18 June 2015

**RE: 255 - 265 MILLER STREET NORTH SYDNEY
WENONA SCHOOL - PROJECT ARCHIMEDES
BCA COMPLIANCE STATEMENT FOR DA SUBMISSION**

This report has been prepared based on a review of the architectural plans prepared by TZG dated 16/6/2015.

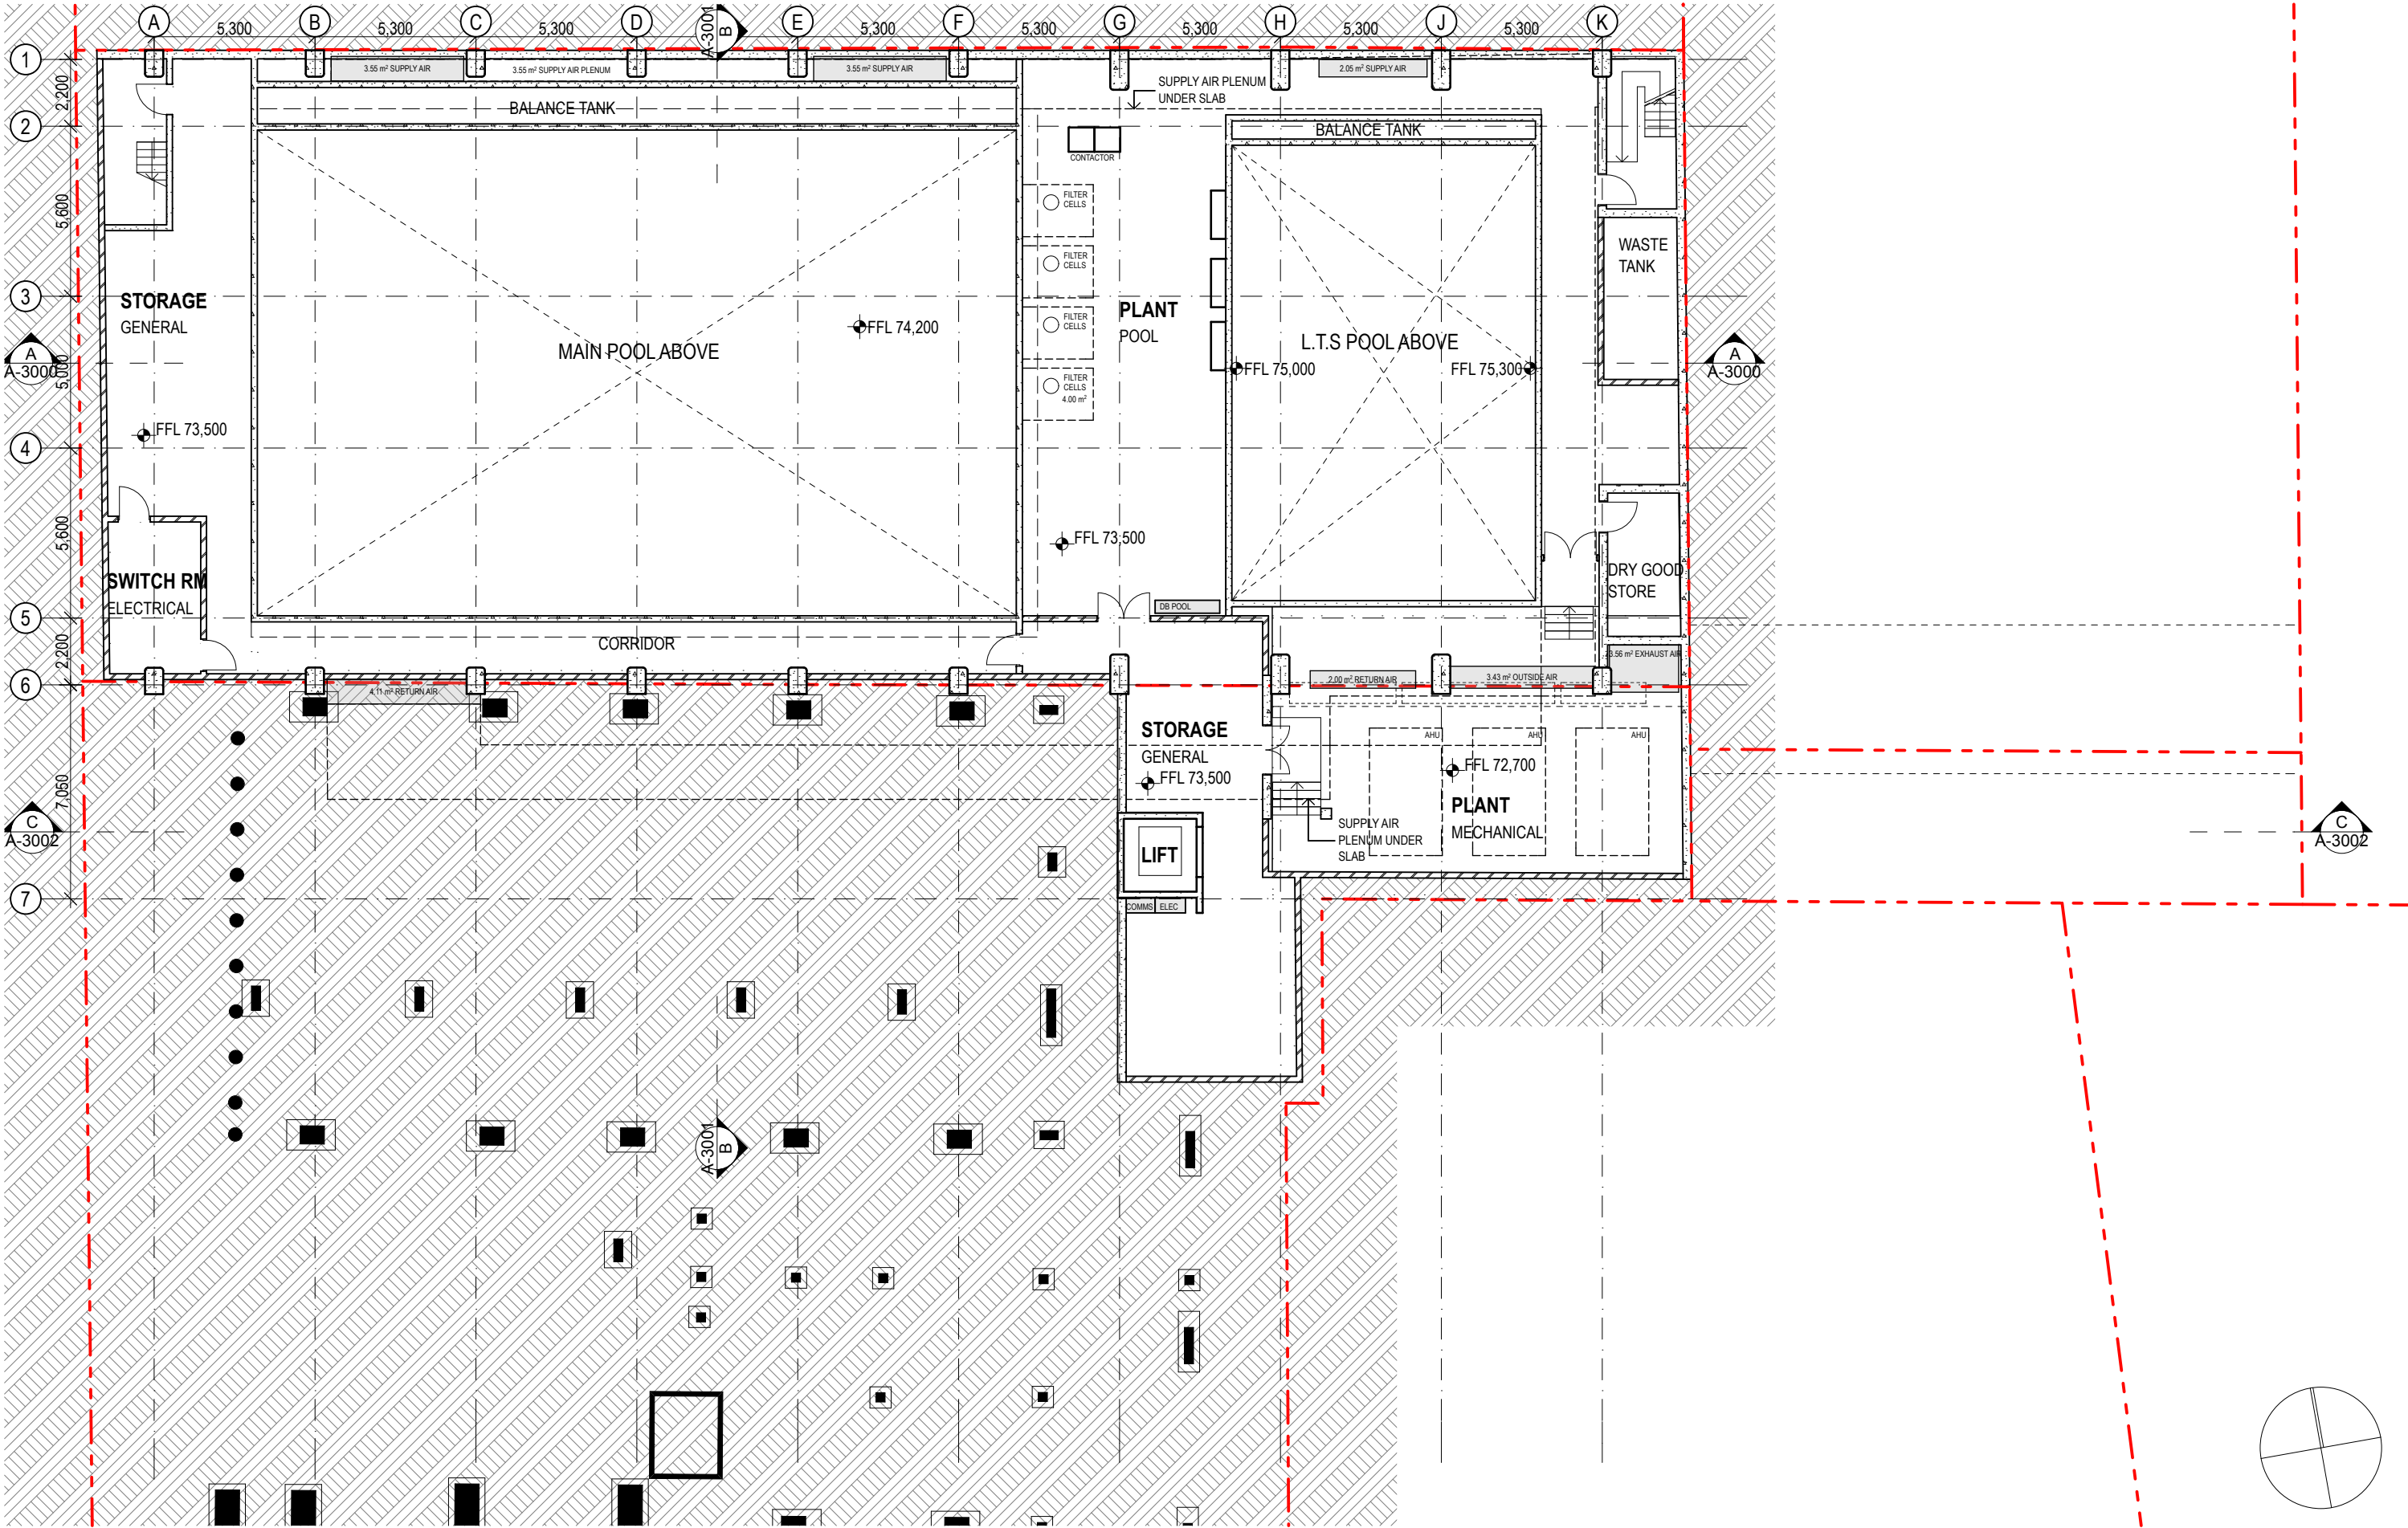
4. BCA cl. D1.5: Distance between alternative exits at Lower Ground 3 (Basement) level is 73m in lieu of BCA DTS prescribed maximum of 60m.
5. BCA cl. D1.3 & D1.7: The required fire isolated exit at Gridline H7 does not discharge to a road or open space, nor to a covered area complying with D1.7(b)(iii).

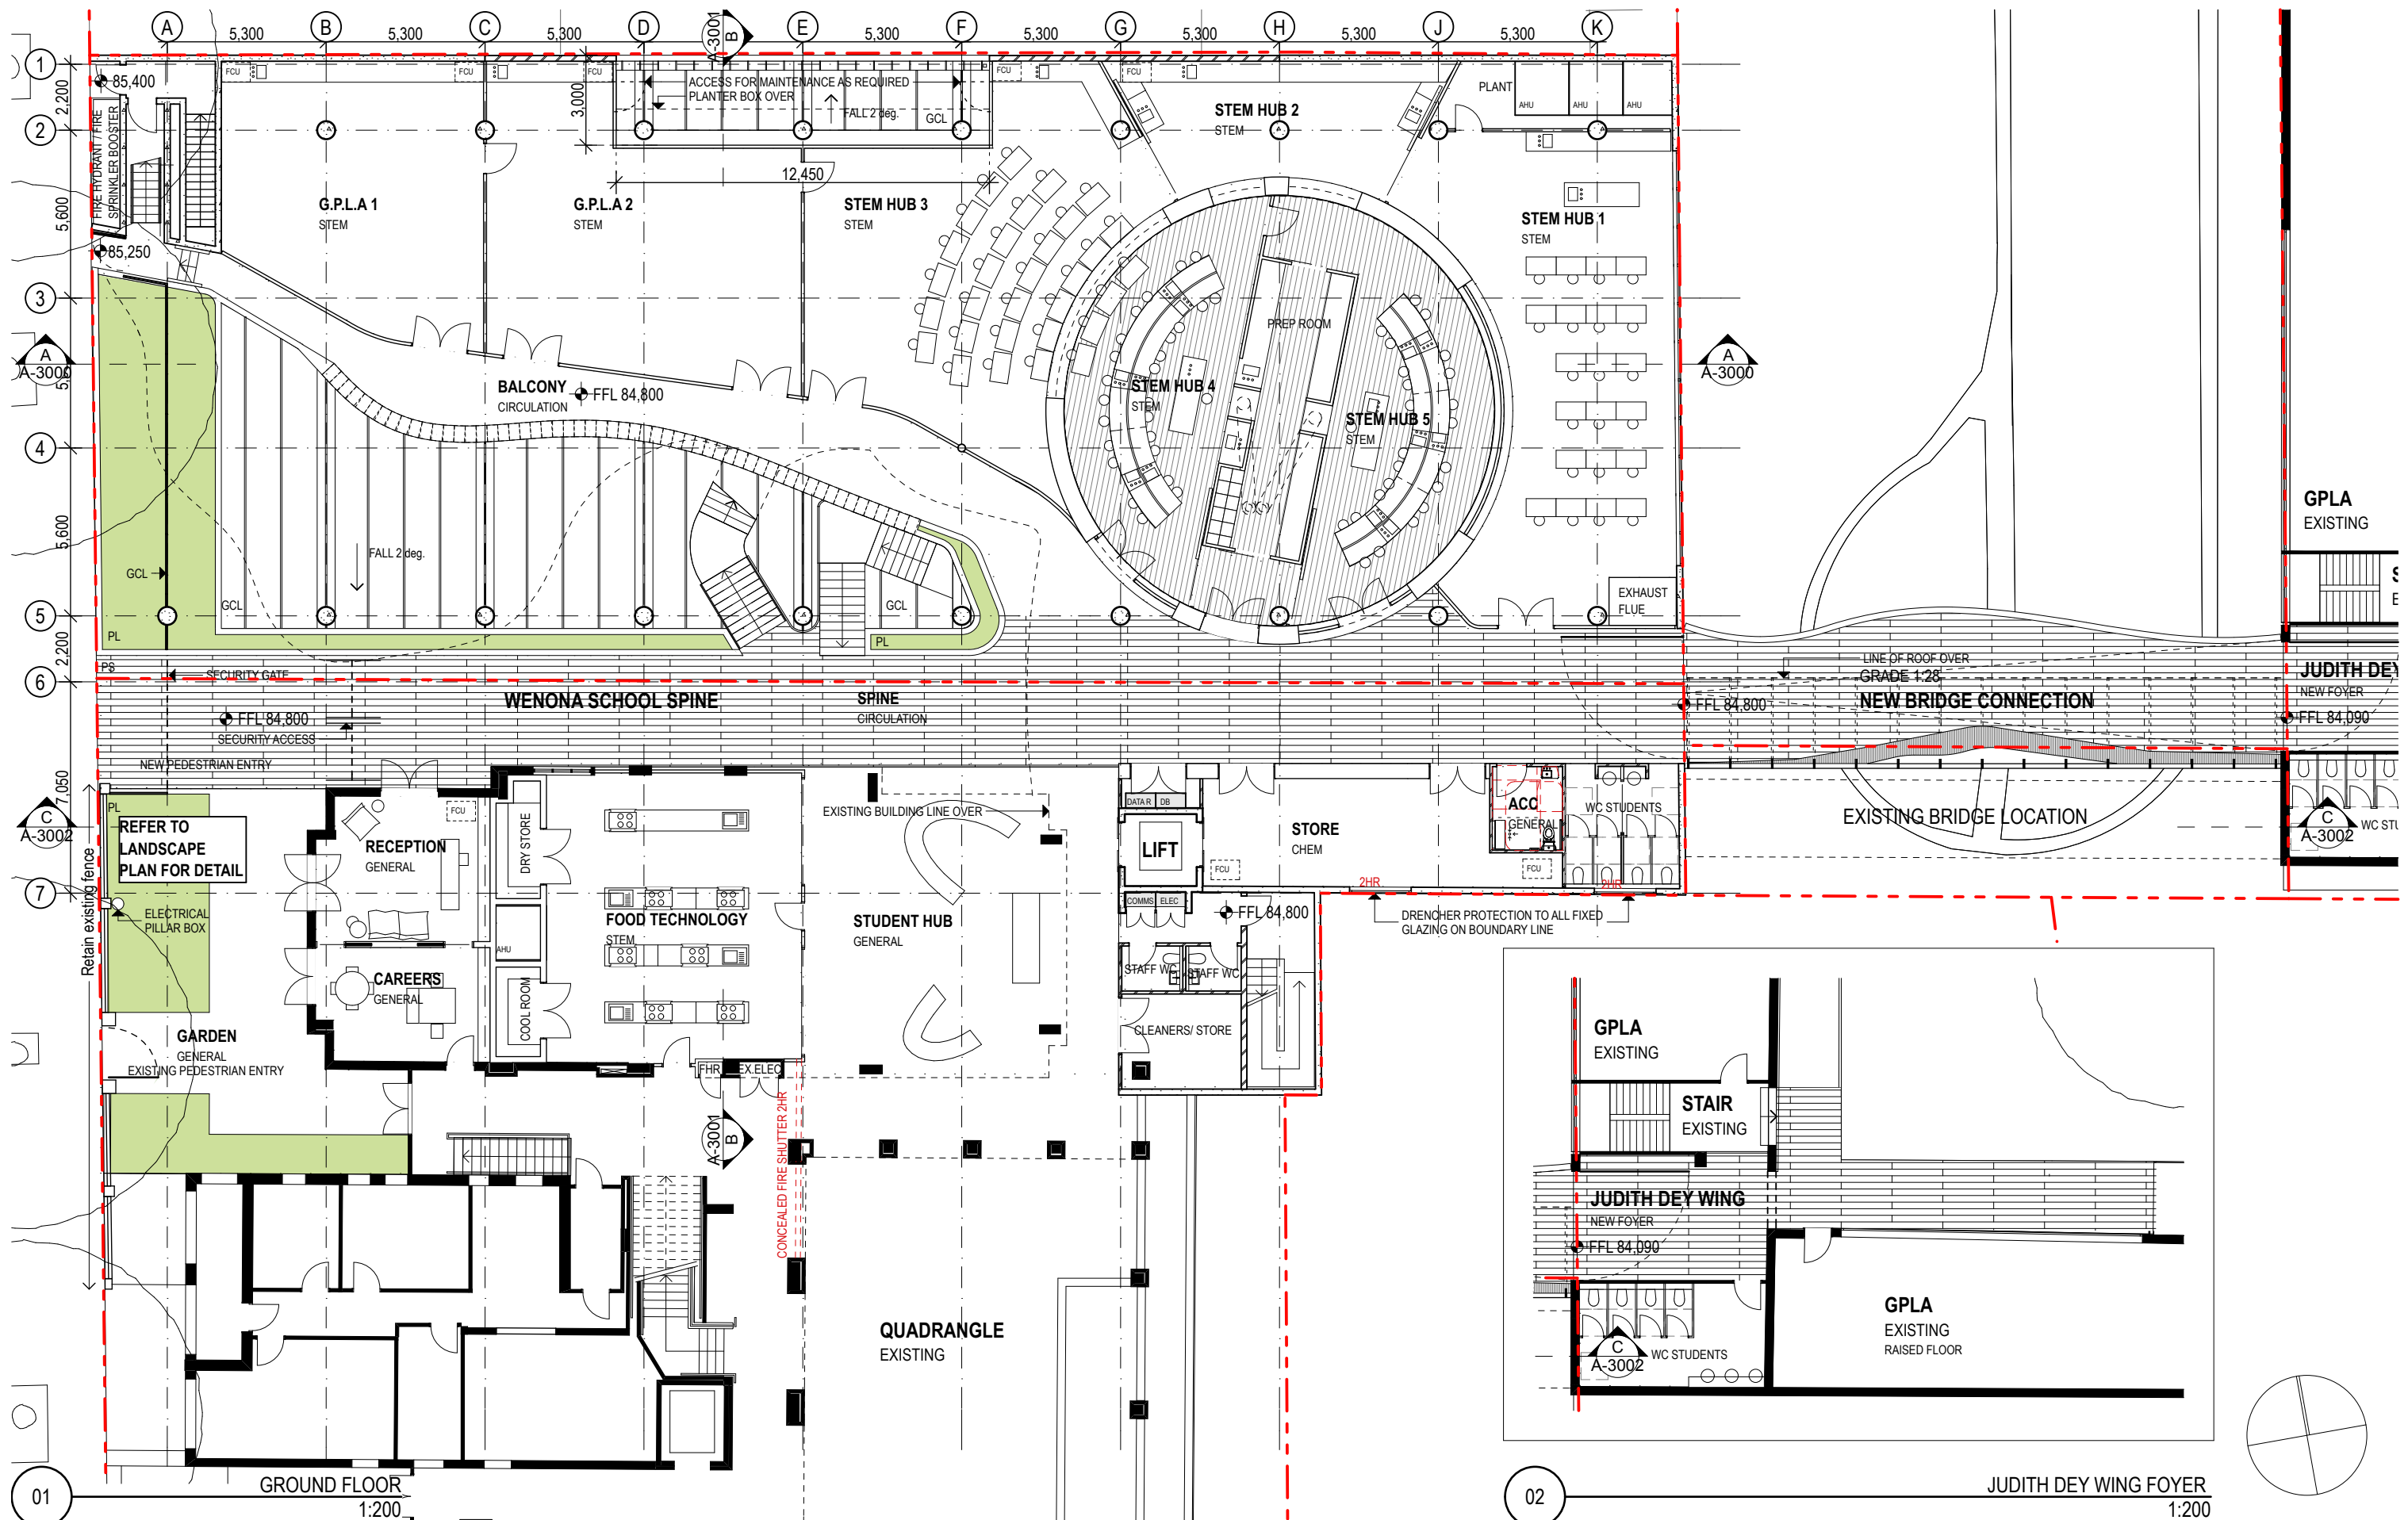
2. BCA cl. C3.3: Openings in external walls of different fire compartments require protection where situated
3. BCA cl. D1.4: Exit travel distance to a point of choice of up to 25m is proposed in lieu of BCA DTS prescribed maximum of 20m at Ground Floor level.
